2021/1037

4 Millcroft, Millhouse Green, Sheffield

The proposal involves the erection of a two storey rear extension to the existing two storey projecting element of the dwelling. The plans have been amended during the course of the application with the materials changed from timber cladding to render, this is due to concerns raised with regard to the proposed timber cladding and the impact on the street scene. The extension would have a brick built plinth to match the adjacent dwellings.

Drawing Title: Elevations - Proposed

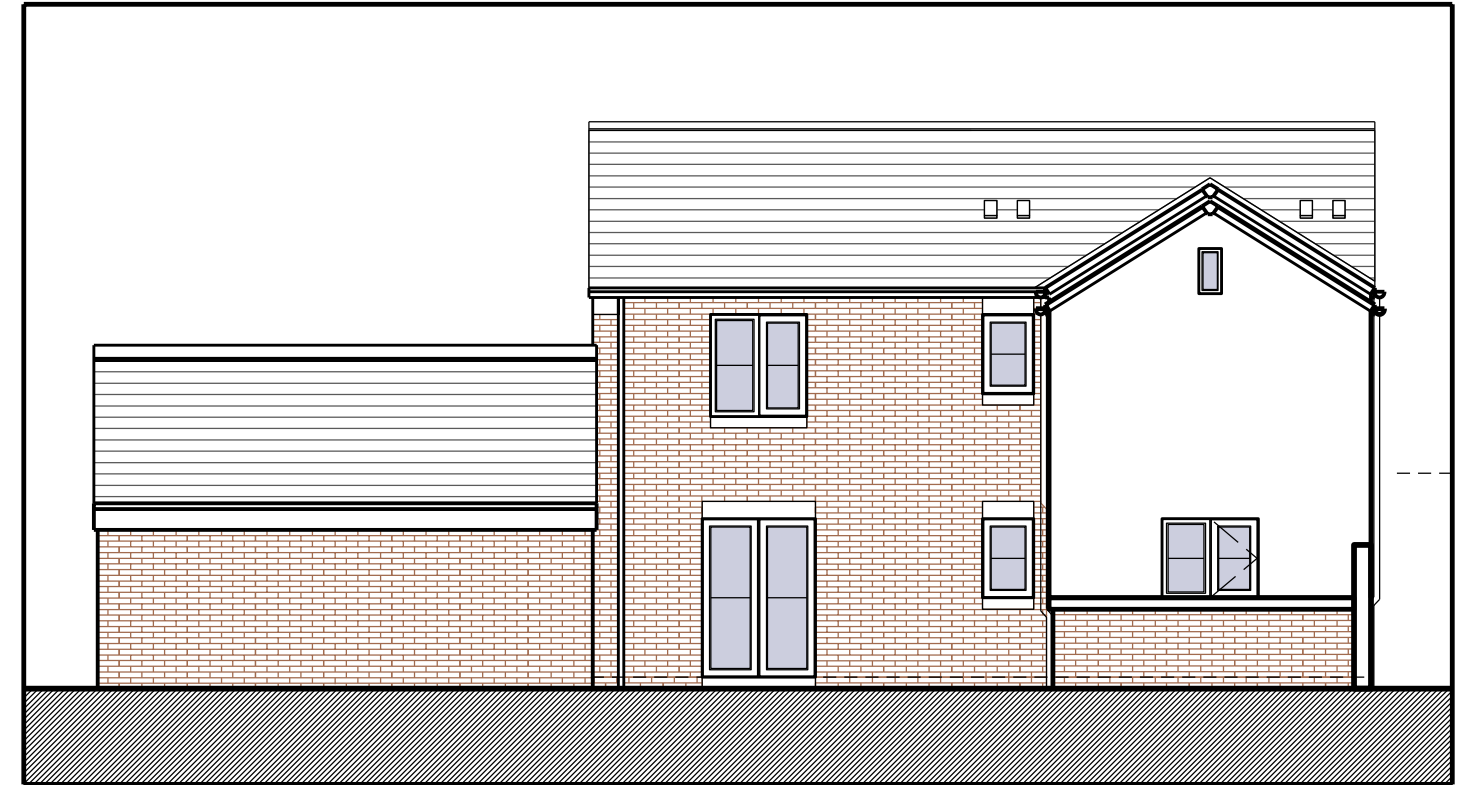
6. materials to match	The materials have been amended during the course of the application from timber cladding to render. The windows have also been altered to match the existing dwelling. The property is brick built however the extension will feature rendered elevations and a brick plinth to match the adjacent dwellings and to break up the expanse of brickwork. Given there are similar rendered dwellings opposite the proposed extension there are no objections to the materials proposed in this instance.

7. roof design compliments / ties in well	Yes pitched to match.
8. habitable room windows on the side elevation?	Yes at ground and first floor to each side. The windows at both ground and first floor to the north elevation of the proposed extension will be screened by the existing garage which has a high roof pitch (photos above) and is set along the boundary with number 2. The existing separation distances are maintained to the first floor windows. The window to the southern elevation will face across the road and would have views over the side elevation of number 8 Millcroft, therefore no significant overlooking would occur and the existing separation distances are maintained. Ground floor windows will be screened by existing boundary treatments.

9. distance to rear boundary (shared with another residential property) 10m or more?	No but only 1 small high level window is proposed to the west facing elevation at first floor level, so no significant overlooking will
